Michael Osgerby (Agriculture) Ltd

Able Marine Energy Park

Summary of oral case put at Specific issue hearings on 11 September

Figure 36.1 Existing drainage pattern at Cherry Cobb Sands

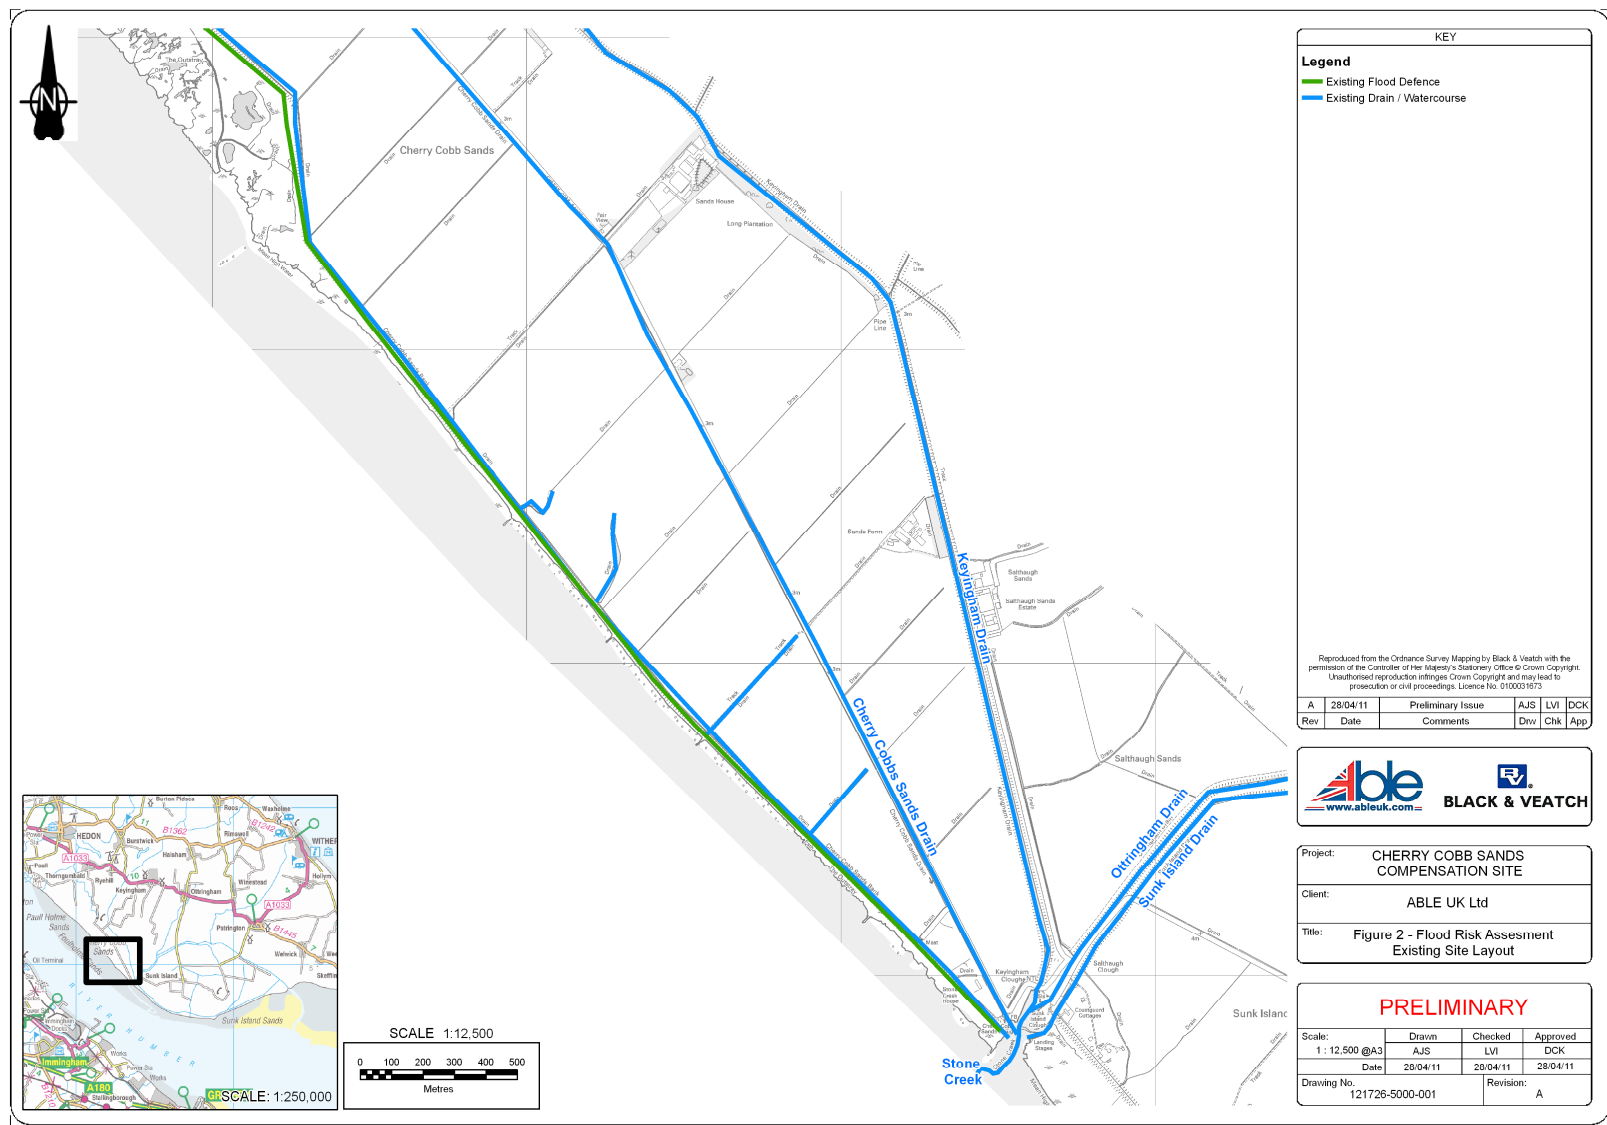
We were concerned at the choice of the new site for roosting & feeding at Stone Creek, for two main reasons:

1. We believe it will be very difficult to create wet grassland on that soil. The soil is very light silt and water drains through it very quickly. Water just disappears downwards on that land. So we cannot see how it will be possible to keep water on the land to make it wet.
2. Keyingham Drain borders the eastern side of the proposed site. This is a very important drain which drains a large area of Holderness, including many villages. Altering the level of this drain will affect its ability:
 - a. to take water away from the center of Holderness, therefore the villages will flood
 - b. to scour out the mouth of the drain at Stone Creek. A large head of water is needed in the drain to flush out the silt in the Creek. If the mouth of the drain is not kept clear, the water cannot escape, so the villages & surrounding areas will flood
